Subject: Application Ref 3/2025/0814 - Startifants Farm

Chipping Parish Council discussed application ref 3/2025/0814 at their meeting on 17th November 2025. The application proposes a car port situated adjacent to the road at Startifants Farm. Councillors felt that the scale of the proposed building, at 4m high to the apex, may have an impact on visibility for road users, particularly those turning out of Startifants Farm and neighbouring properties.

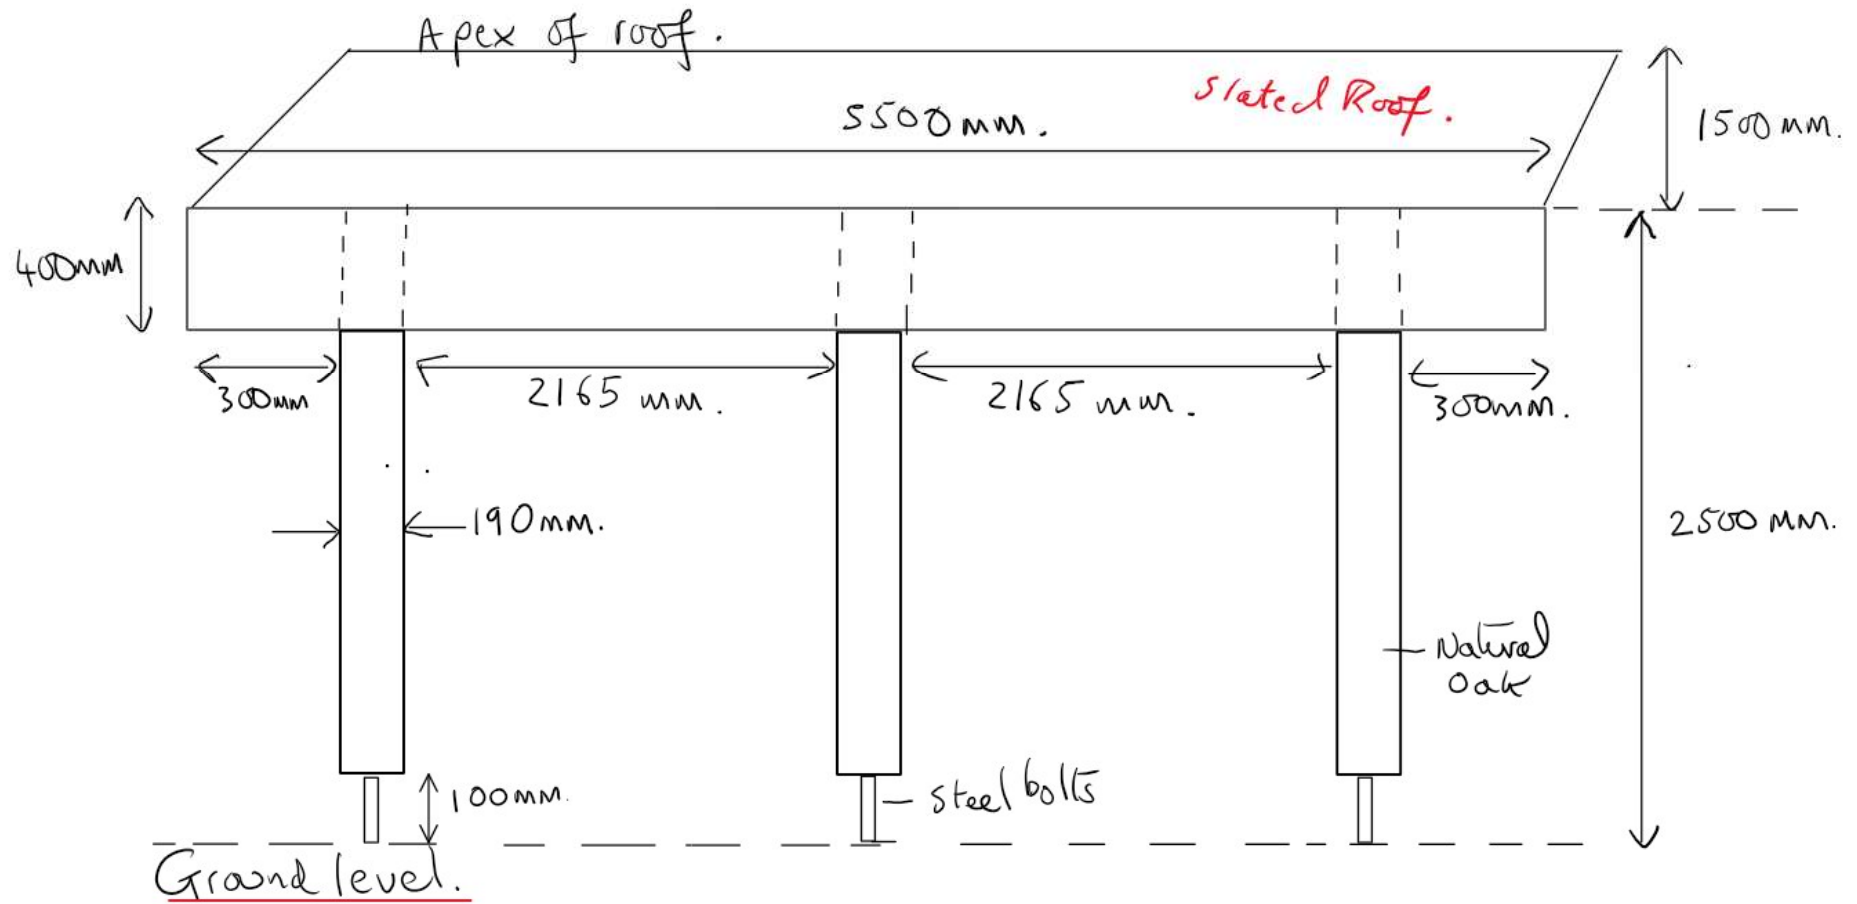
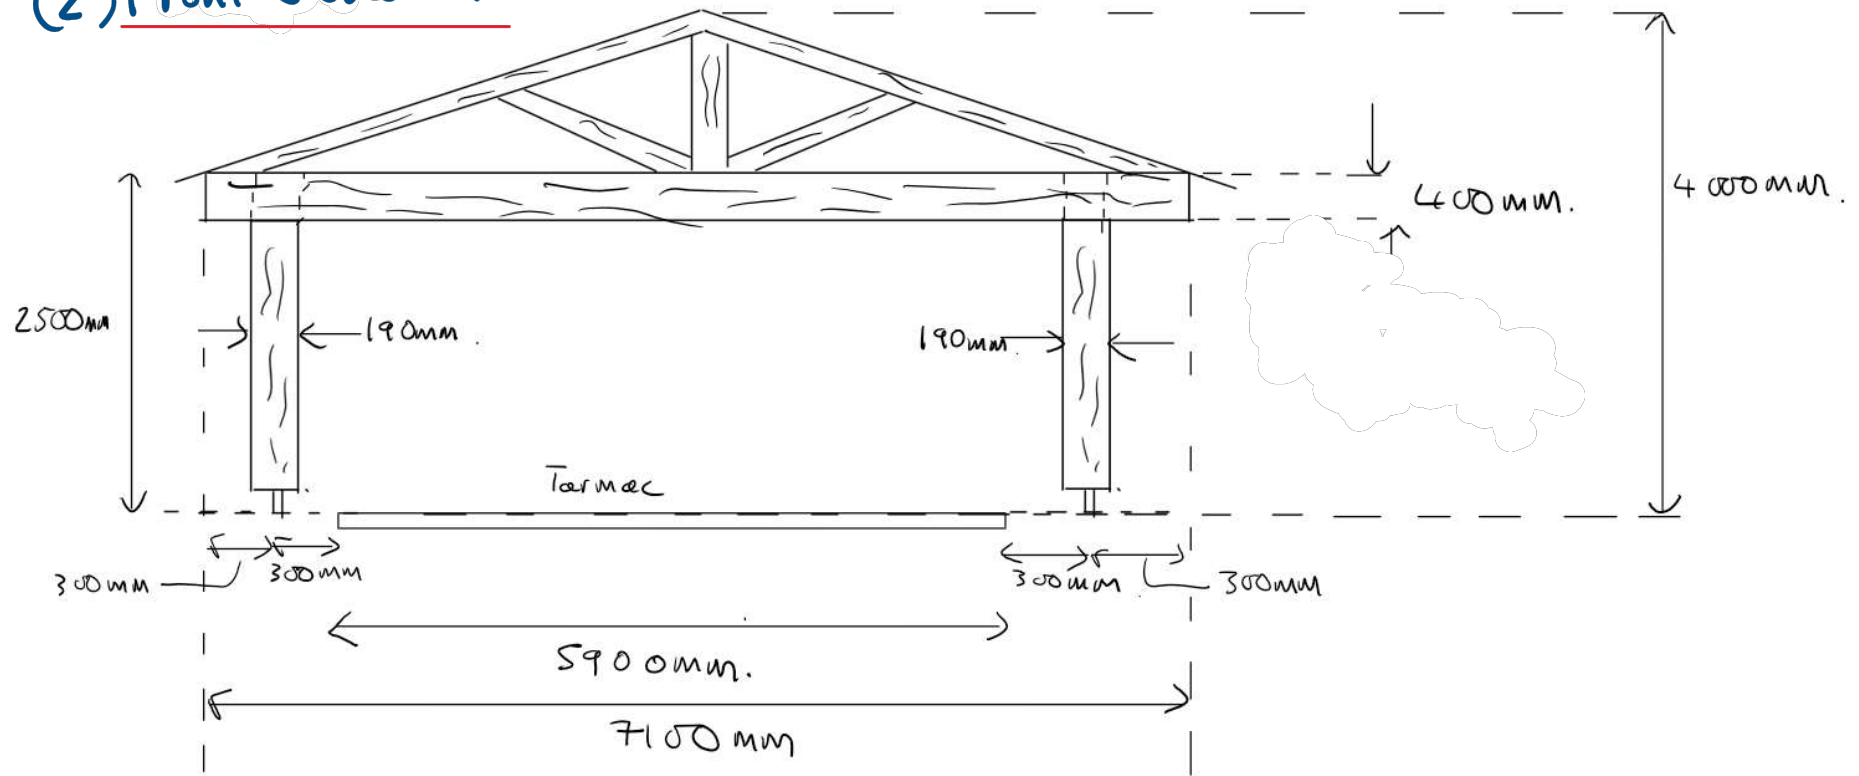
We ask that LCC Highways consider the position and size of the proposed building regarding visibility of approaching traffic from exits on to the highway as it is not clear from the drawings included with the application if there will be a negative impact.
